Our Ref: DOC18/384279

RE: Notice of Exhibition – Sydney Football Stadium Redevelopment, 40 – 44 Driver Avenue, Moore Park (SSD 9249)

Based upon this review, as delegate of the Heritage Council of NSW, I provide the following comments:

FIGURE 10: APPROXIMATE SURVEY OF BUSBY'S BORE (N.B. THIS SURVEY MAP HAS BEEN PROVEN TO HAVE MANY INACCURACIES) (SOURCE: SYDNEY WATER ARCHIVES, REF: A1029)

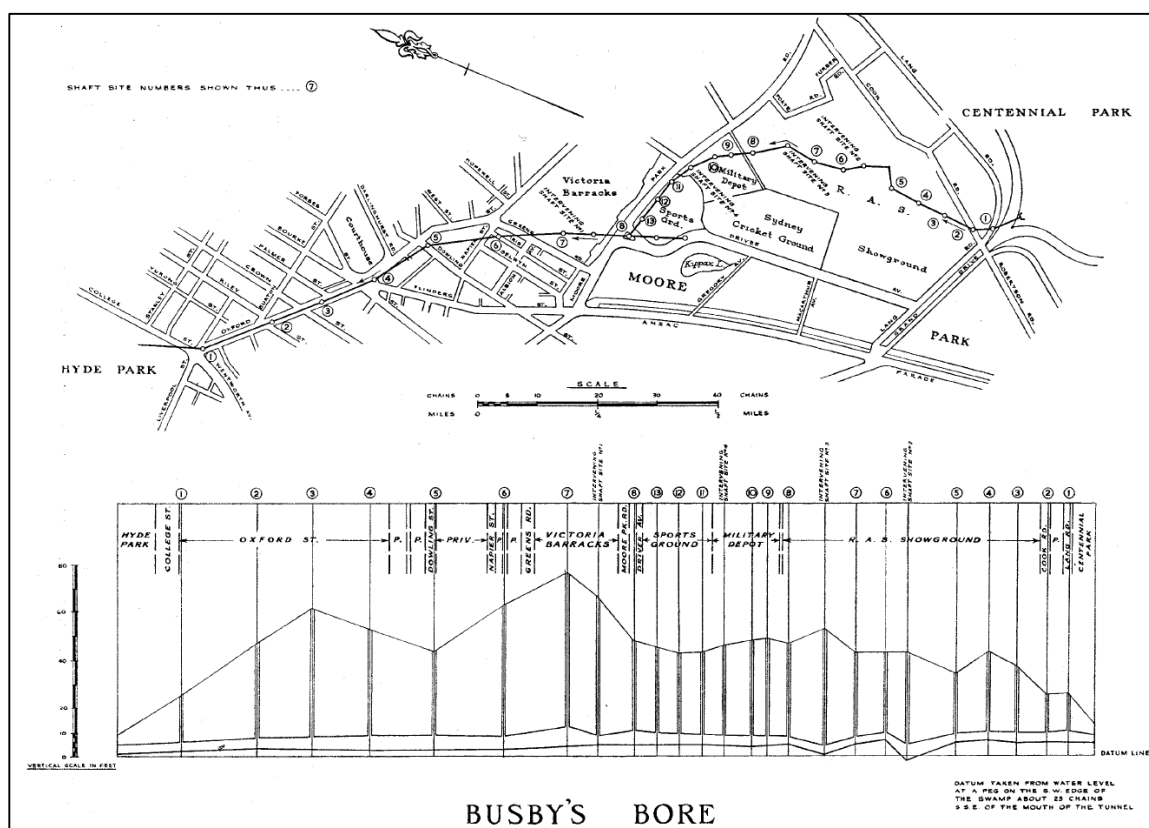
- *Busby's Bore* should be subject to additional investigation to confirm its precise locations within the site. This is essential to informing the detailed design stage to ensure this State Heritage Register item is protected and should occur as soon as possible.

- *Busby's Bore* should be avoided by the project to ensure the significance of this item is retained. All measures should be considered to avoid this item from direct or indirect impacts, including obtaining the advice of a structural engineer.
